City of Albuquerque Stormwater Construction Site Inspection Report

Project Name and Location	Cuatro Development 4th and Summer		
Site Contact Name & Agency	Kevin Cobos Tofel Construction	Contact Phone #/ E-mail	480-707-3903
Date of Inspection	4-5-17	Start/End Time	12:15/12:20
Inspector Name, COA Dept.	Curtis Cherne, Stormwater Quality		
Inspector Phone / E-mail	505-924-3420/ccherne@cabq.gov		
Inspector Qualifications	Qualified Compliance Inspector of Stormwater- Stormwater One		
Describe Present Phase of Construction	Stabilized

From: Cherne, Curtis
Sent: Friday, April 10, 2015 8:10 AM
To: 'Kevin Cobos'
Subject: RE: SWPPP at Greater Albuquerque housing on 4th street

EROSION CONTROL PLAN

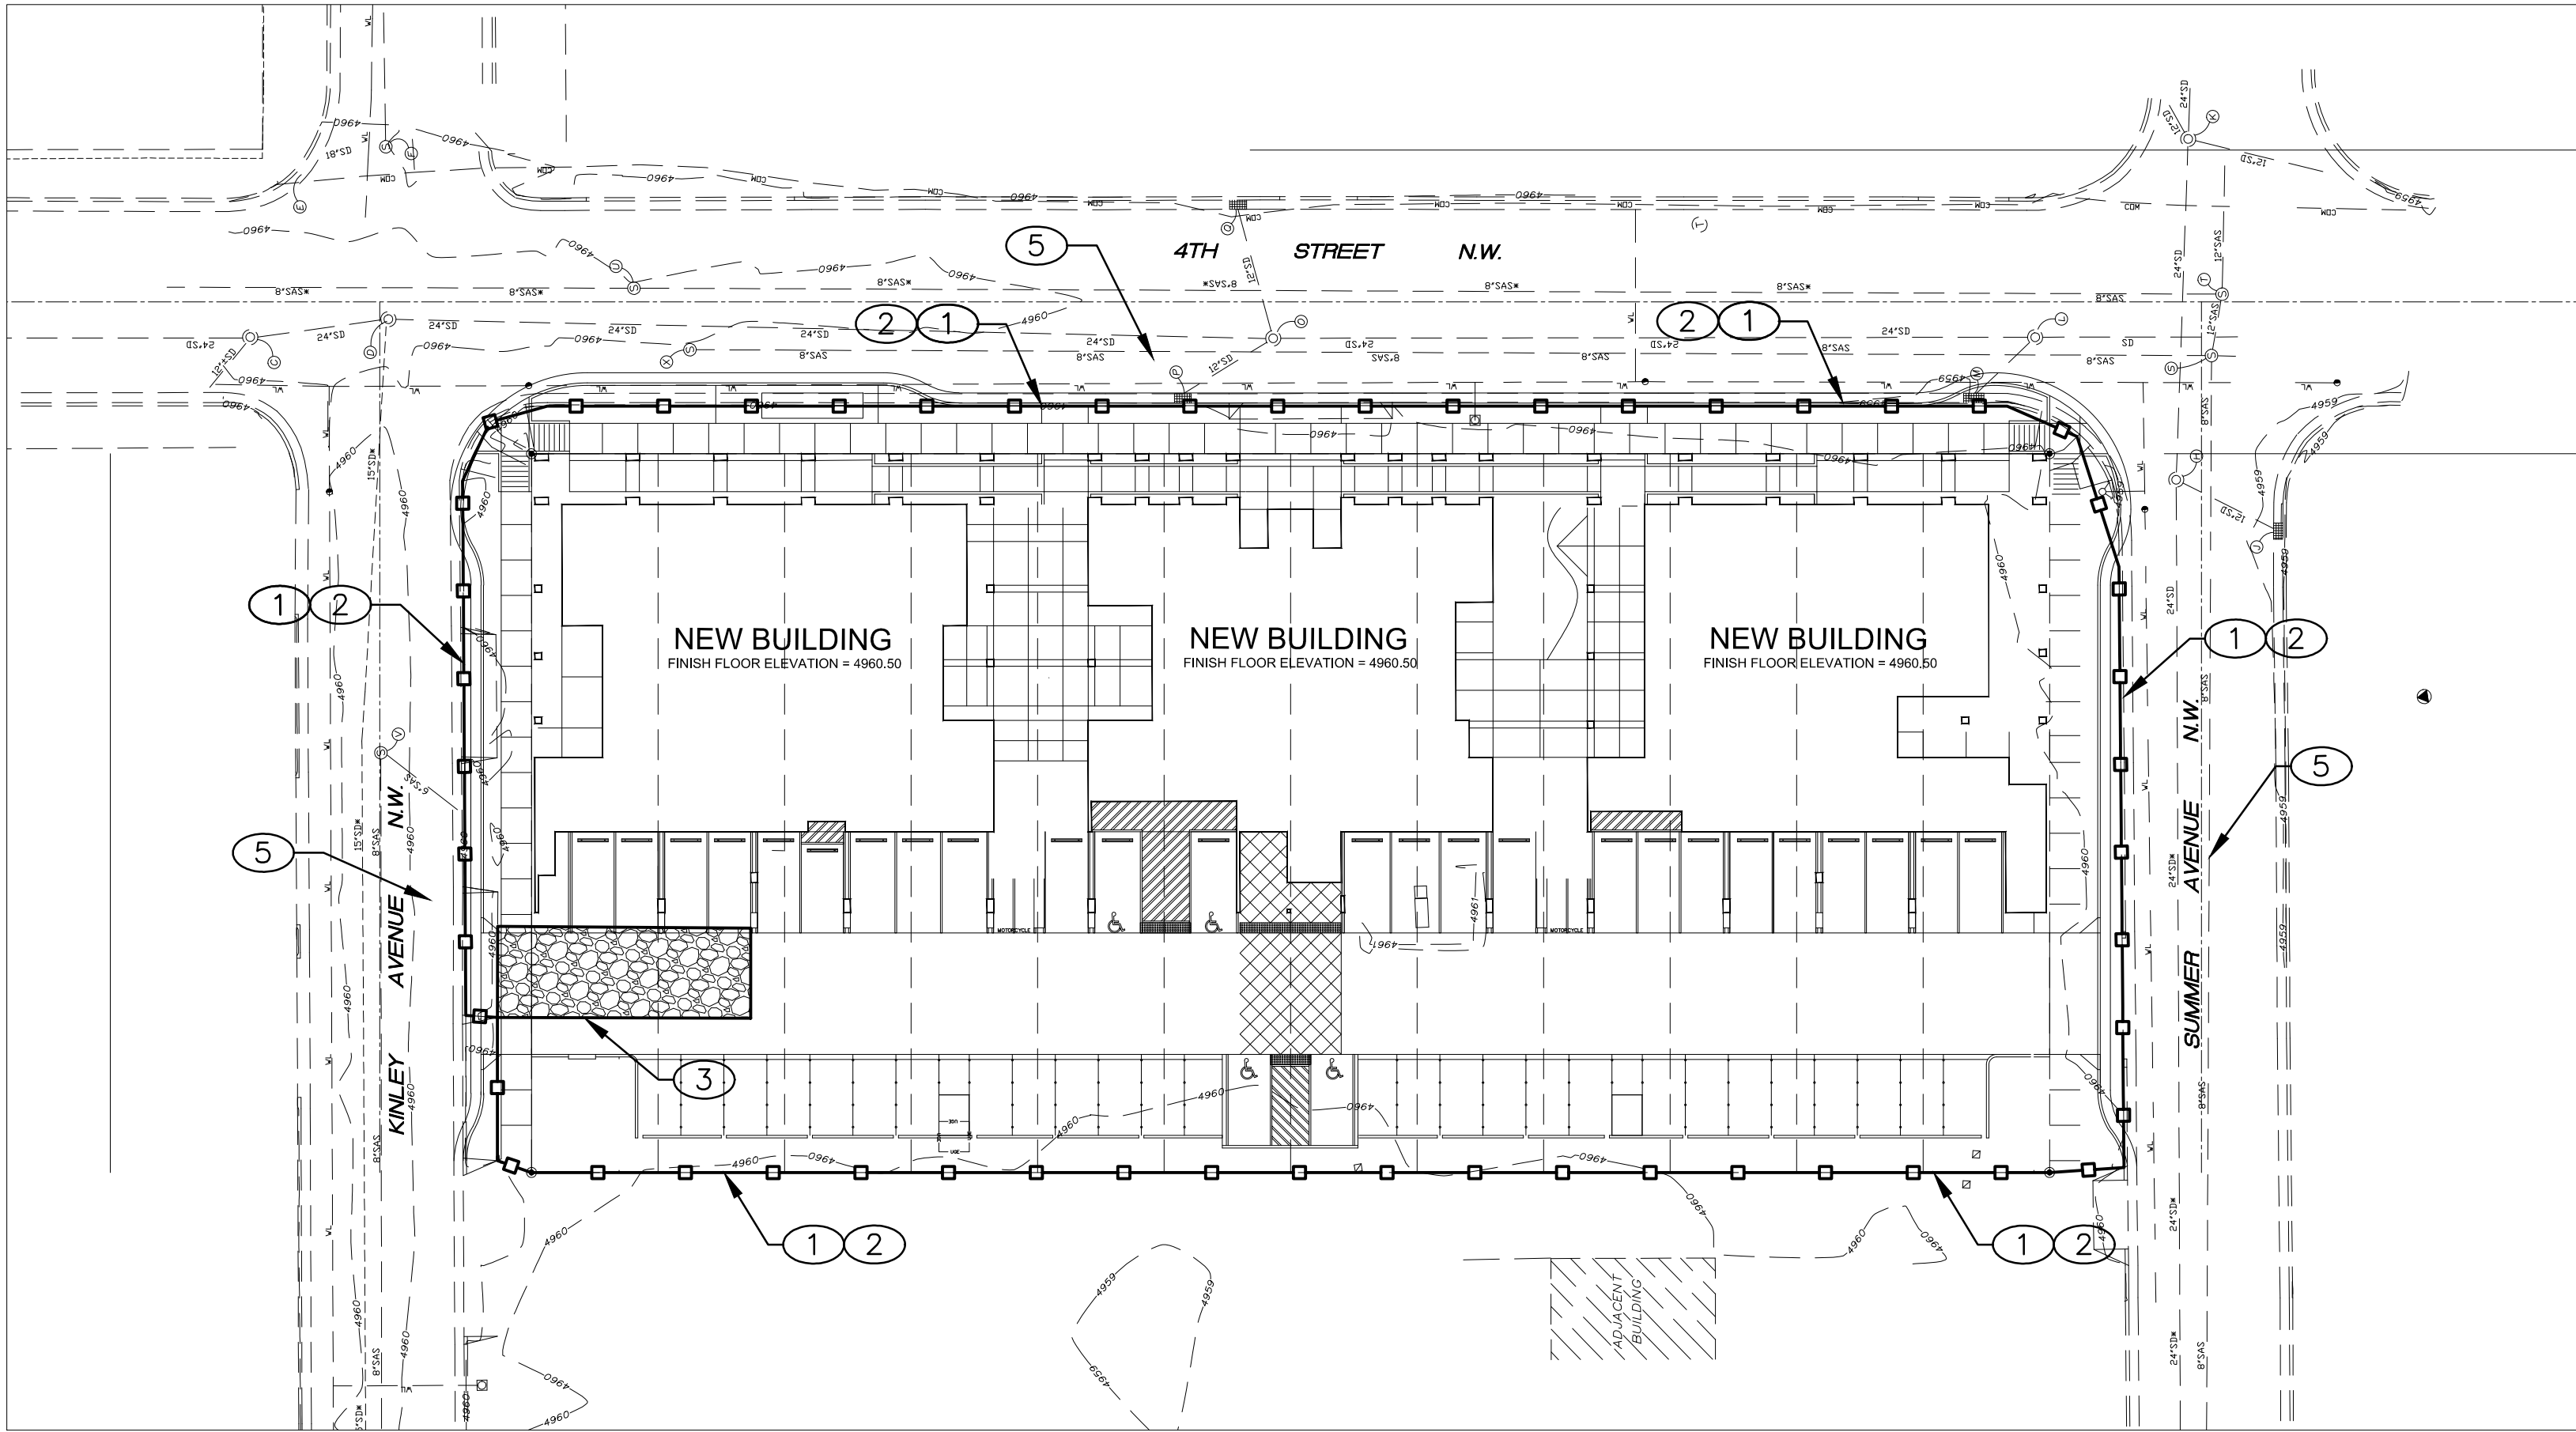
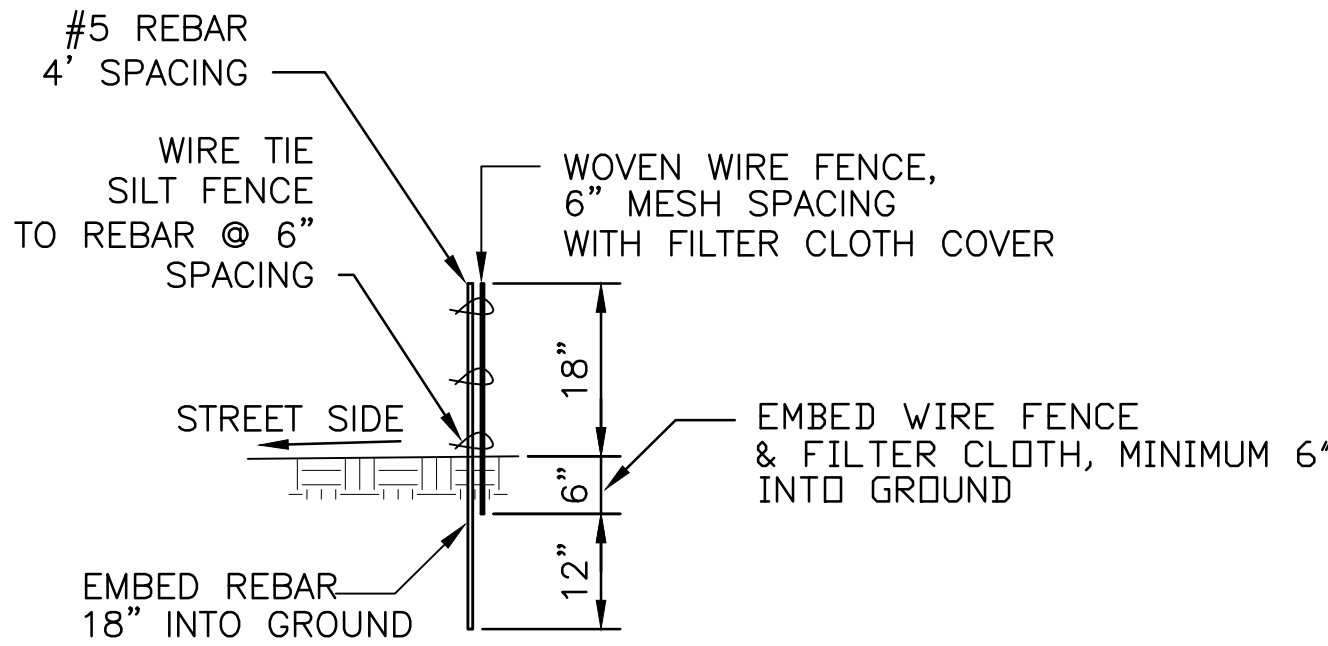
- ☒ Entrance / Off Tracking minor off-tracking, dirt in gutter for ramp not built at 3 drops
- ☒ Sediment Controls / Silt Fence, Check Dams, Waddles, etc. 25' section on Summer Ave needs repair
- ☐ Erosion Controls / Mulch, Seed, _____
- ☐ Wind Blown Erosion _____
- ☐ Housekeeping / Pollutant Controls _____
- ☐ _____

1. 25 feet of silt fence needs repair on Summer Ave.
2. The construction entrance was moved away from the curb cut, so dirt is being used as a ramp.
3. I couldn't find the required posting board per the Construction General Permit.

1. silt fence will be repaired
2. due to over excavation my entrance had to go in this place for safety concerns. I actually have cold patch for the ramp if this is an issue I will fix immediately.
3. the sign, is there a specific SWPP sign that needs to be hung? Or the fugitive dust sign only?
